Application for a non-material amendment following a grant of planning permission

OUTLINE APPLICATION (ACCESS LAYOUT, SCALE, APPEARANCE) FOR DEMOLITION OF STABLES AND ERECTION OF RESIDENTIAL DEVELOPMENT FOR 3 SELF-BUILD / CUSTOM BUILD DWELLINGS INCLUDING ASSOCIATED WORKS.

2024/93046

Drawing Number:
37/2405/10

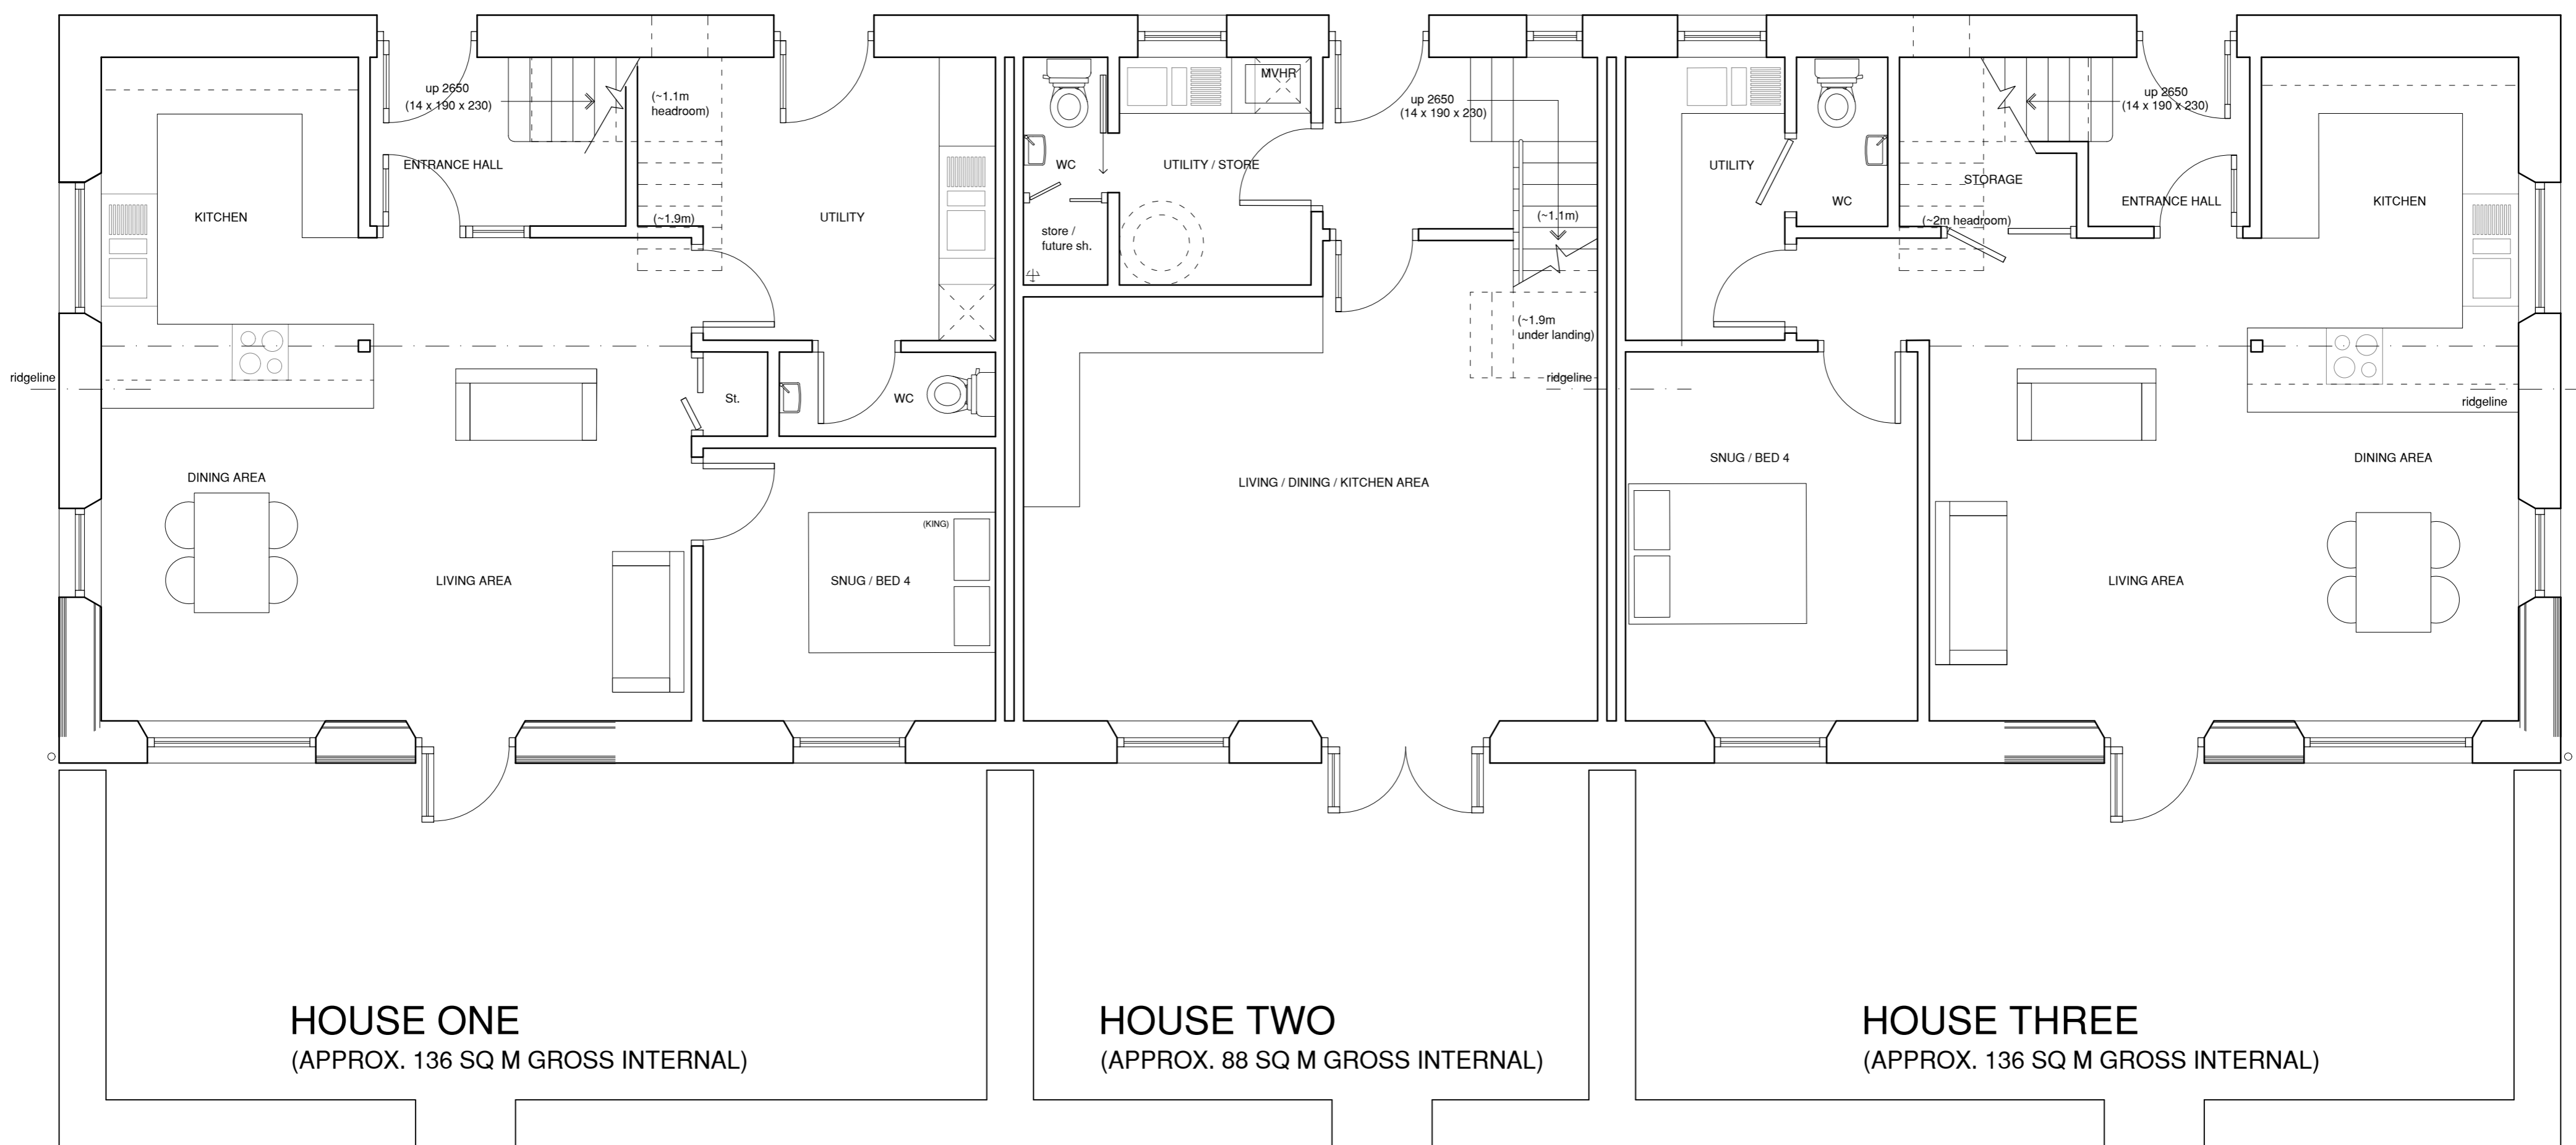
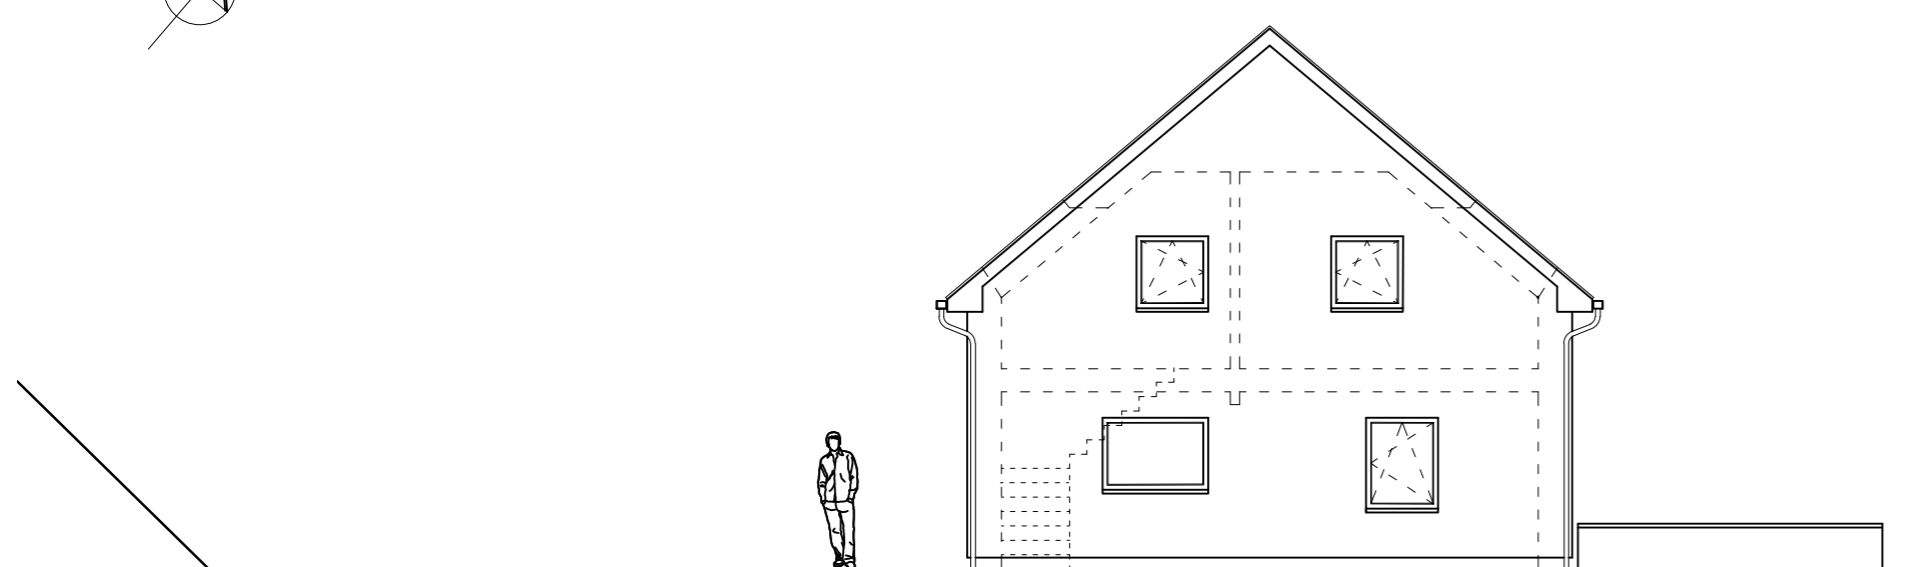
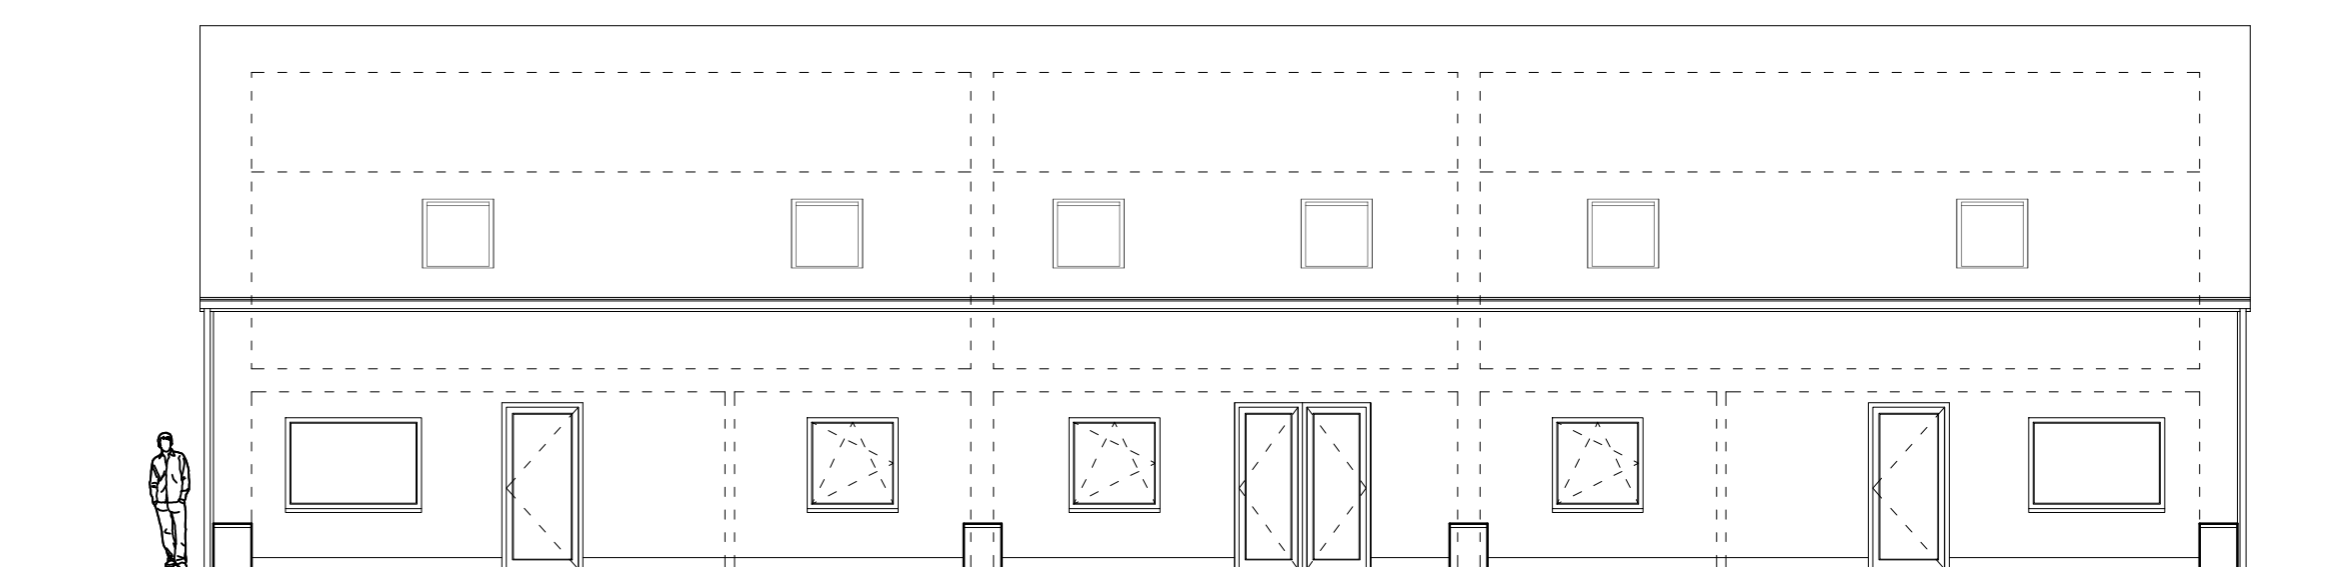
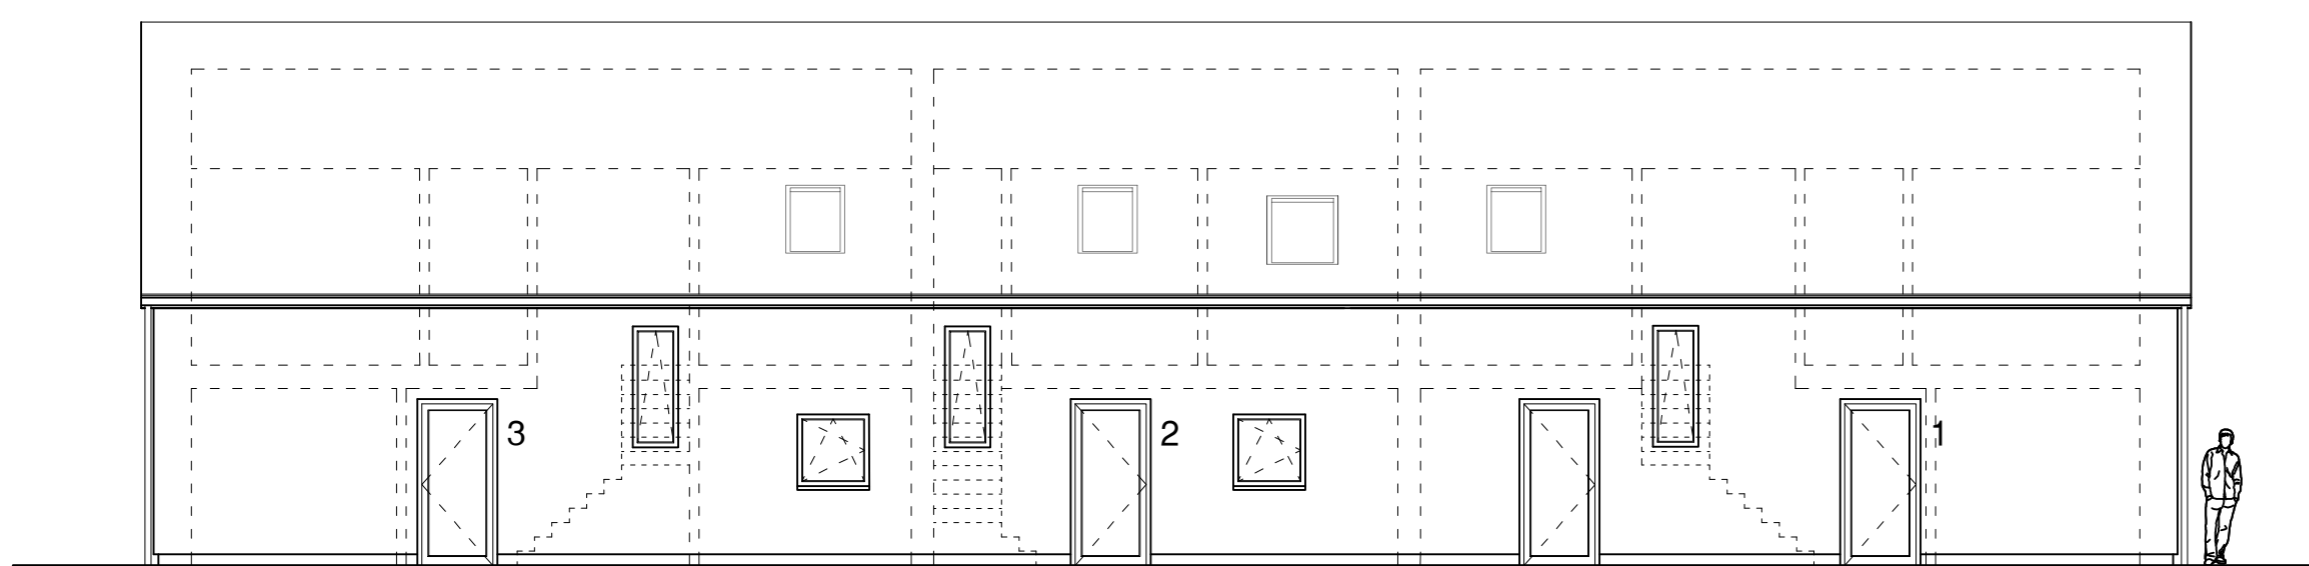
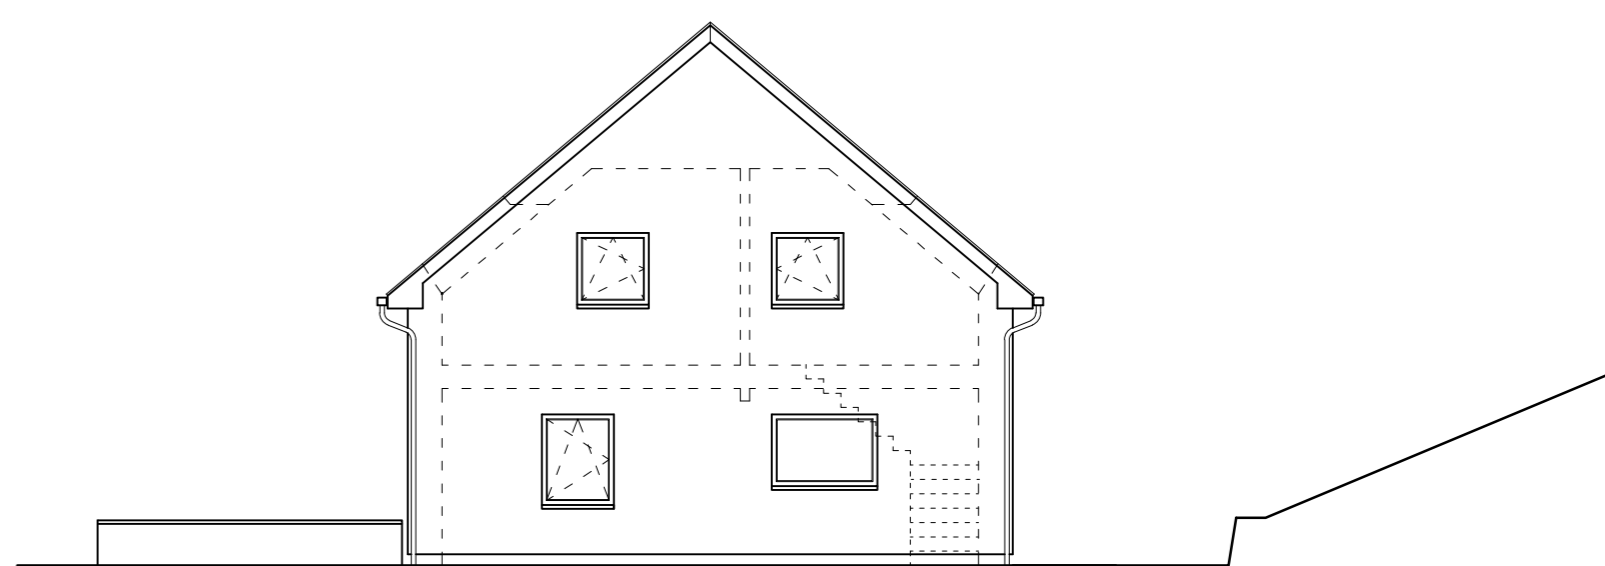
1. FENESTRATION - MINOR CHANGES TO LOCATION AND DETAIL
DOORWAYS - MINOR CHANGES TO LOCATION AND DETAIL
2. INTERNAL LAYOUT - MINOR CHANGES WHICH HAVE NO ADVERSE EXTERNAL IMPACT.
3. MINOR INCREASE IN RIDGE HEIGHT

1. FENESTRATION/DOORS - CHANGES FOLLOWING PASSIVHAUS MODELLING RE OVERHEATING AND DAYLIGHTING ISSUES.
2. TO PROVIDE PROTECTED MEANS OF ESCAPE FROM FIRST FLOOR AND TO OPTIMISE ACCESSIBILITY, FUTURE PROOFING / DISABLED LIVING.
3. TO INCREASE RIDGE HEIGHT TO ACCOMMODATE INCREASED INSULATION TO COMPLY WITH PASSIVHAUS CERTIFICATION REQUIREMENTS.

AND TO OPTIMISE PHOTOVOLTAIC OUTPUT BY INCREASING ROOF PITCH.
